CITY OF ALBUQUERQUE

April 14, 2017

Re: Hotel Chaco
2000 Bellamah Ave NW
Request 60-Day Temporary C.O. – Accepted
Engineer's Stamp dated: 7/31/2015 (H20D033)
Certification dated: 1-18-17

C1.101

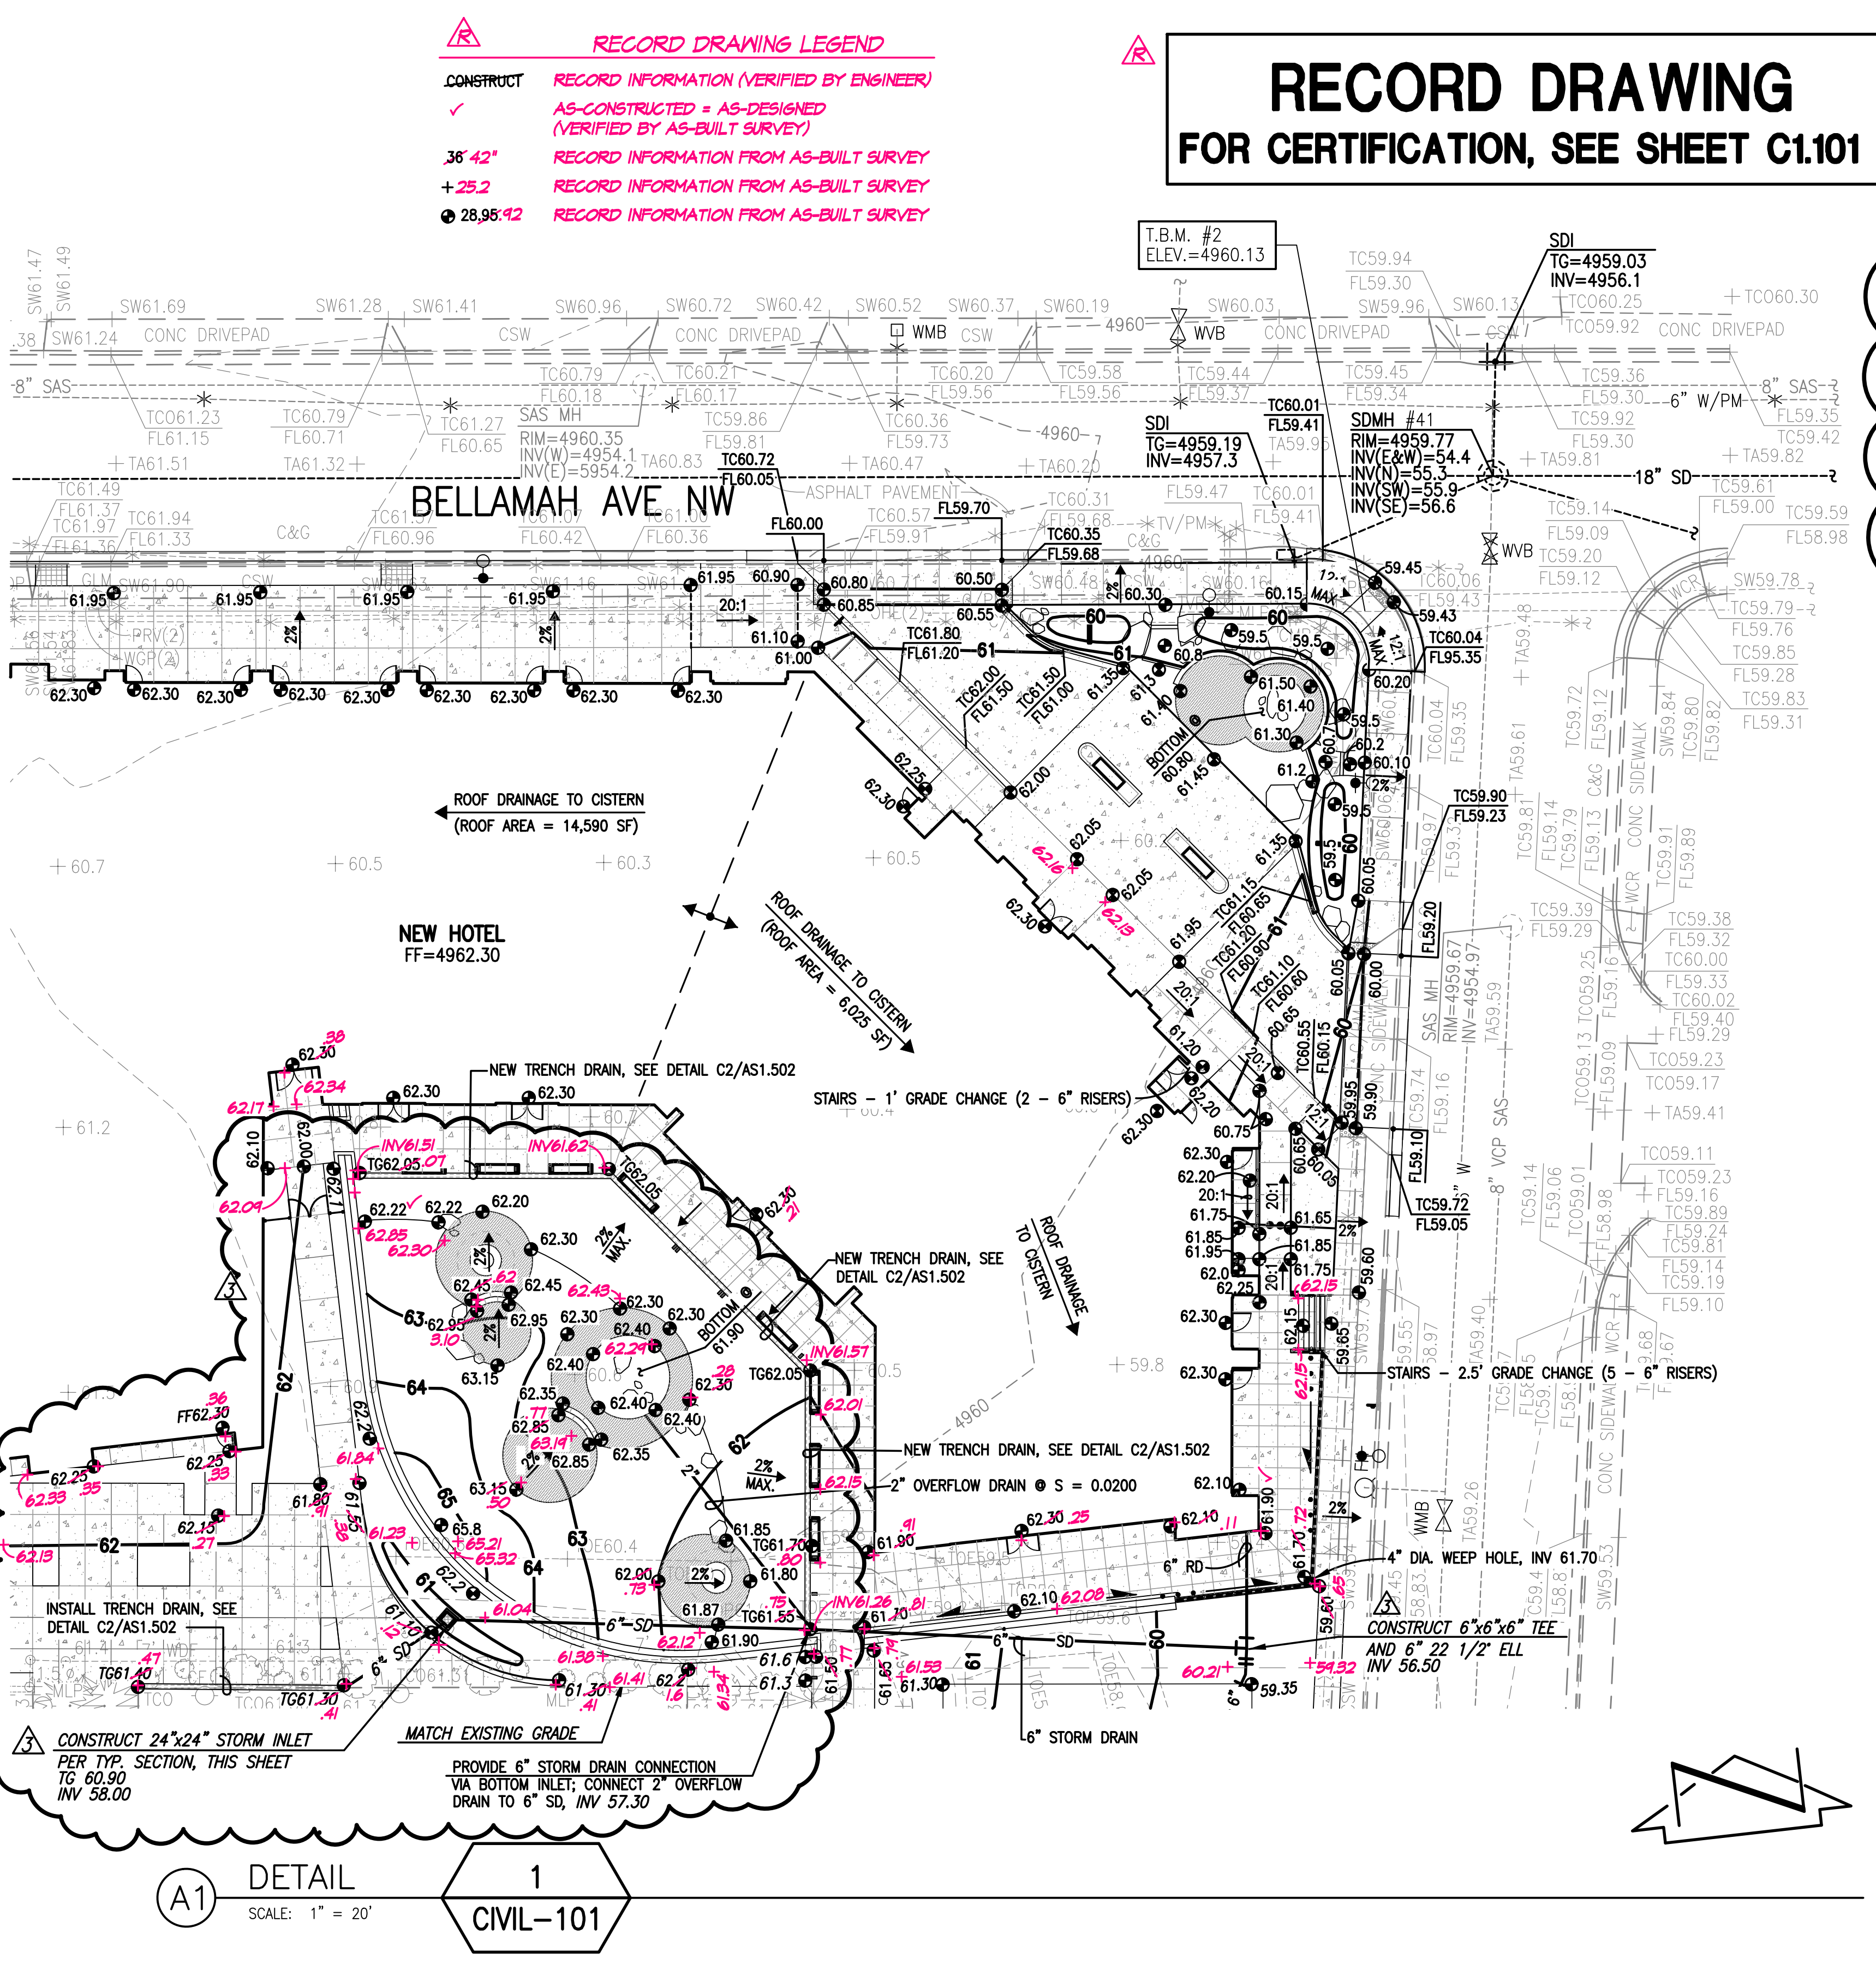
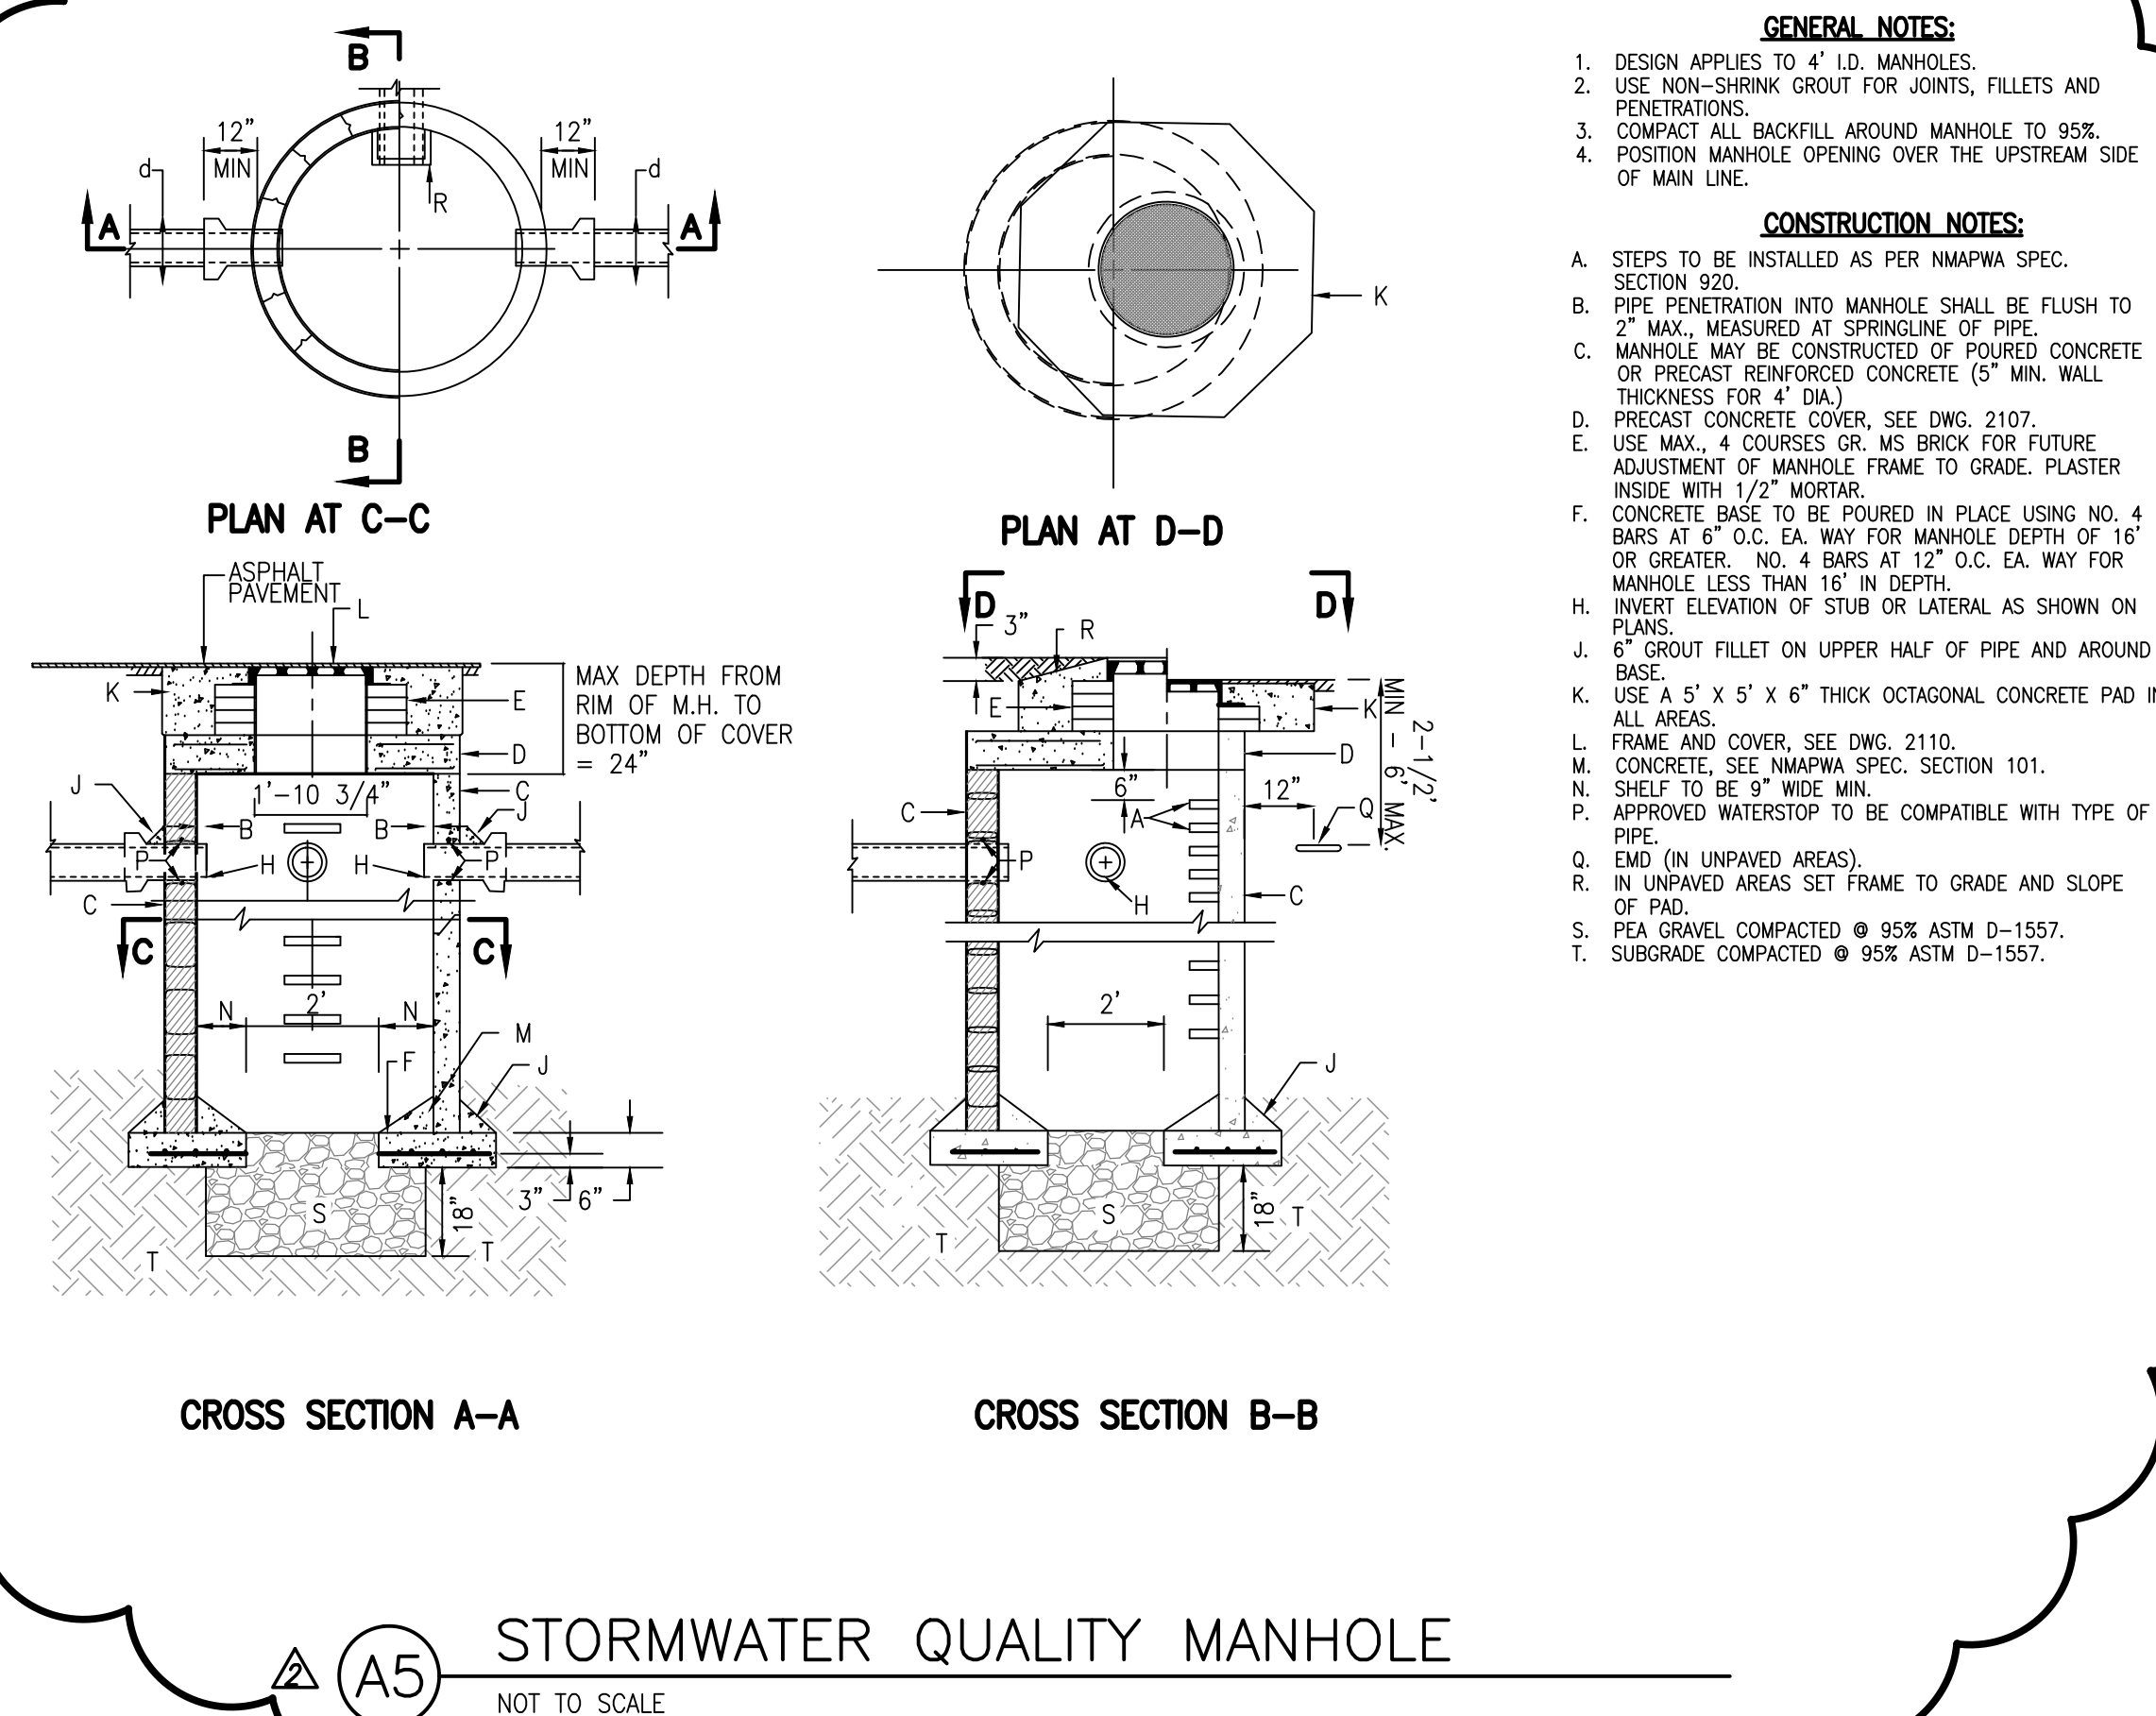
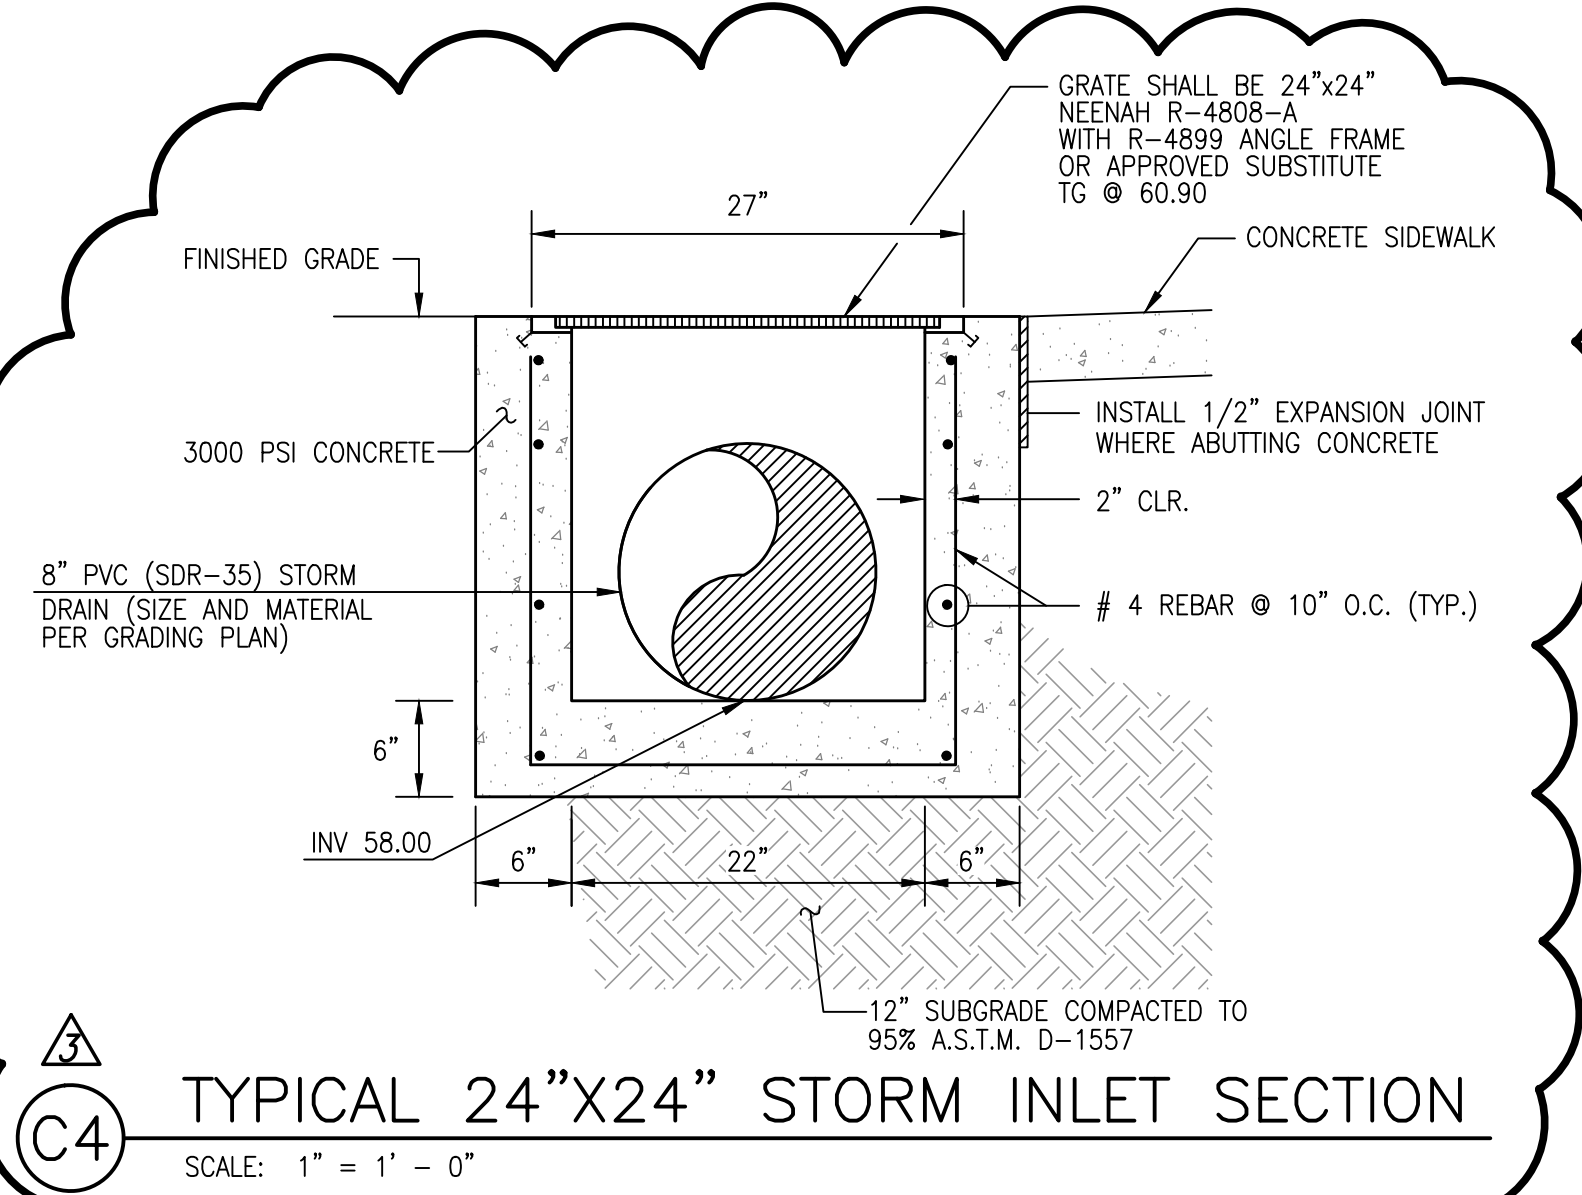
- The sidewalk culvert on Bellamah is incomplete. Must be extended 1' west of sidewalk and east side must be extended to street.
- Note #6 inlet appears to be in mechanical courtyard and not at NW corner of building. Clarify inlet location on drawing.
- Note #13 water harvesting area is incomplete.
- Roof drain at SW corner of building is not on drawing.
